From: Laura Gibbons <Laura.Gibbons@arun.gov.uk>
Sent: 14 September 2021 13:09
To: Planning.Responses <Planning.Responses@arun.gov.uk>
Cc: Michael Eastham <Michael.Eastham@arun.gov.uk>
Subject: RE: Planning Consultation on: BE/121/21/RES

Engineers Comments Regarding Surface Water Drainage

Application No: BE/121/21/RES

Site Address: Unit 3 Land At Salt Box West of Shripney Road Bognor Regis PO22 9NW

TITLE	UNITS 3 DRAINAGE LAYOUT
-------	----------------------------

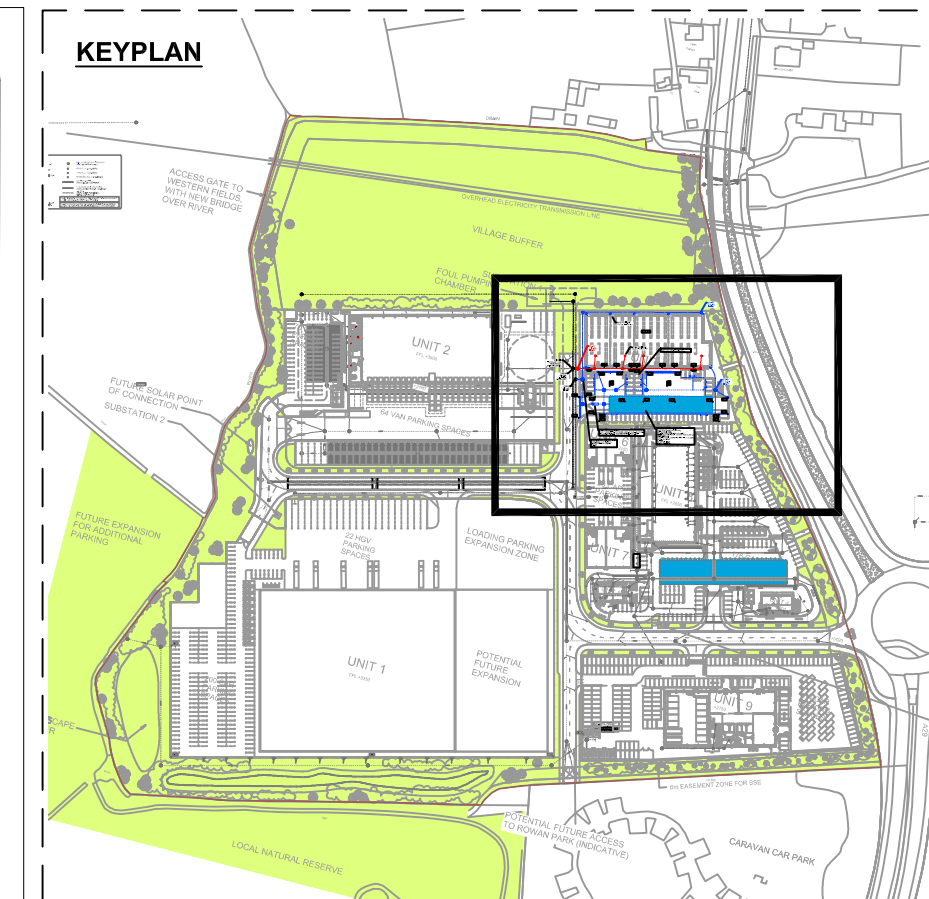
Details of surface water drainage will need to be agreed under a separate discharge of conditions application. The drainage drawing submitted is in broad accordance with the strategy submitted at outline. Please DO NOT list this drainage drawing as approved under this application.

We note that two trees are proposed along the line of the surface water drainage network. Trees must not be planted directly over pipelines and should be positioned so that their root potential areas do not overlap with surface water drainage features. The tree roots will likely damage the pipeline and result in failure of the network, we therefore object to the proposals as they currently stand. Please can a revised landscaping plan be submitted which evidences that proposed trees will not detrimentally impact the drainage.

Please re-consult us once revised landscaping plans have been provided.
